Department of Planning and Environment

3 February 2022

**Residential Development at 89 John Whiteway Drive, Gosford (SSD-10321-Mod-1)  
Response to Submissions Report and Request for Information**

DRAWING TITLE  
BASEMENT

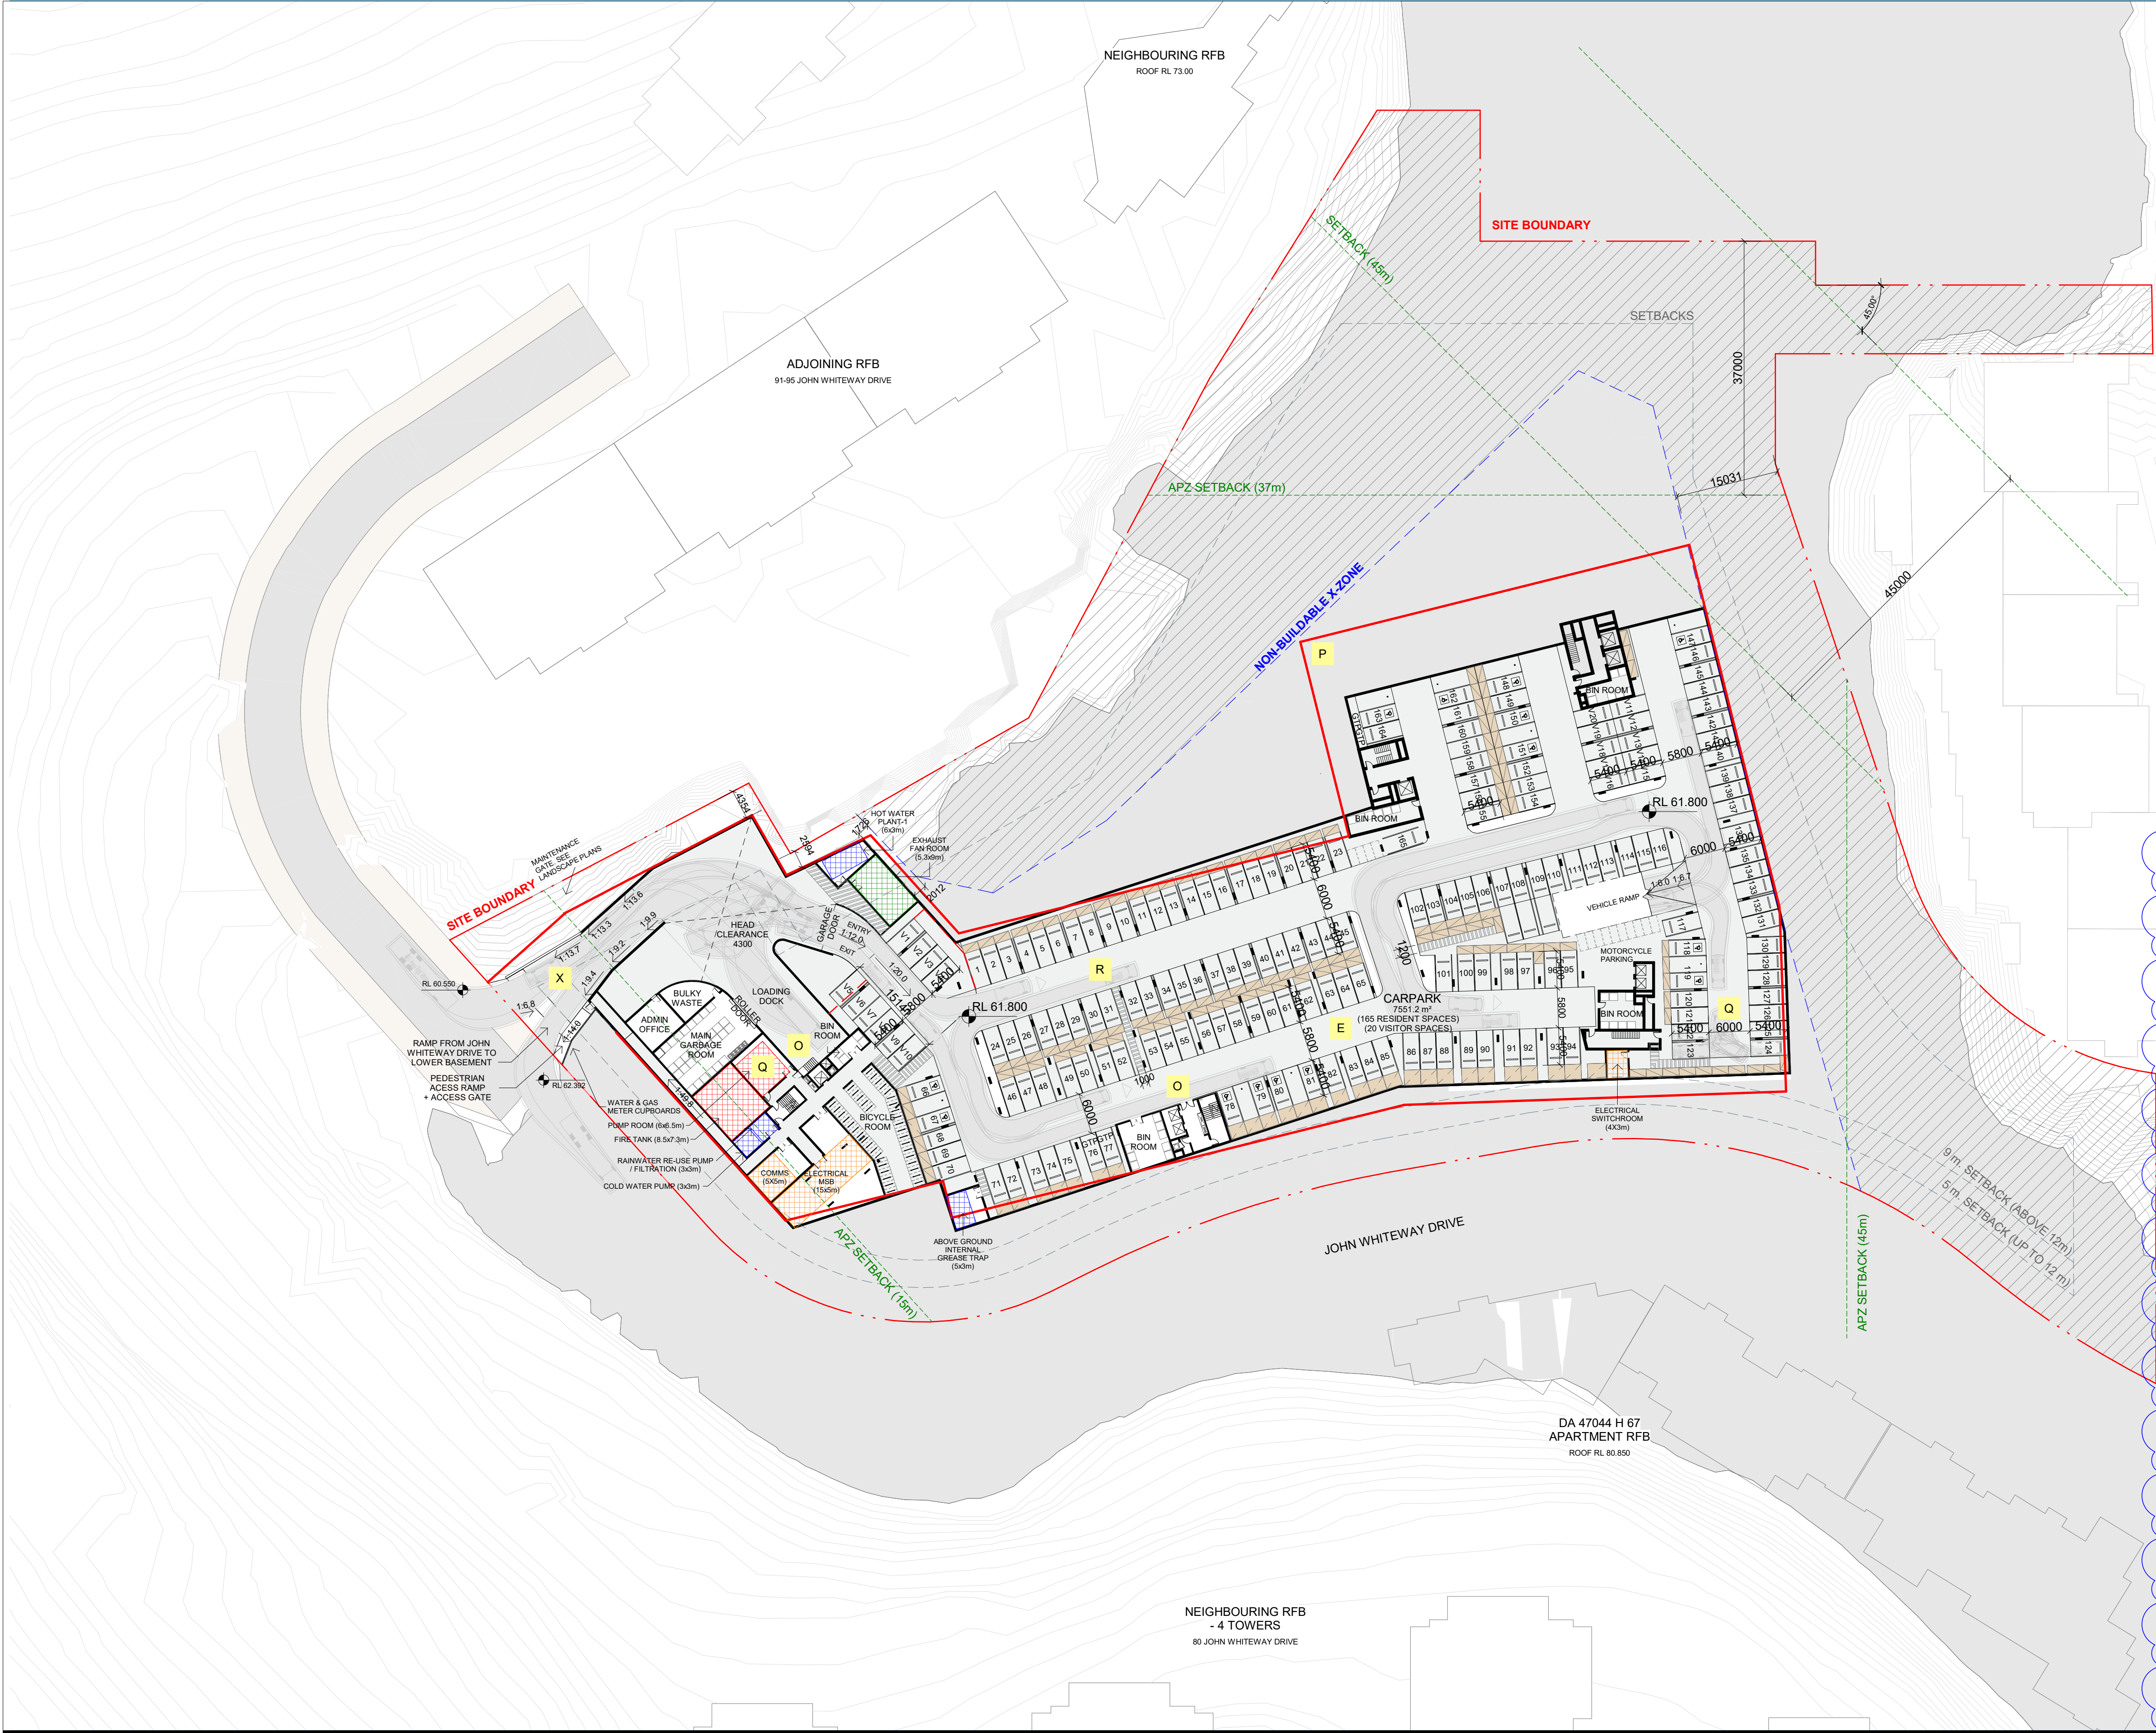
The Neighbourhood Shop has a proposed floor area of 99.7m<sup>2</sup> with 3 parking spaces provided. Under Gosford City Centre Development Control Plan 2018, parking for a 'shop' is to be provided at one space per 30m<sup>2</sup>. The Department requests that parking be amended to ensure that the required 4 spaces are provided.

The parking spaces designated for the Neighbourhood Shop are located within the broader carpark, behind both the security gate and garage door. The Department considers that this location is impractical and the spaces are unlikely to be utilised by customers given they would be unable to access this area. It is recommended that the designated parking spaces be relocated to a more practical location to ensure they can be utilised by both staff and customers.
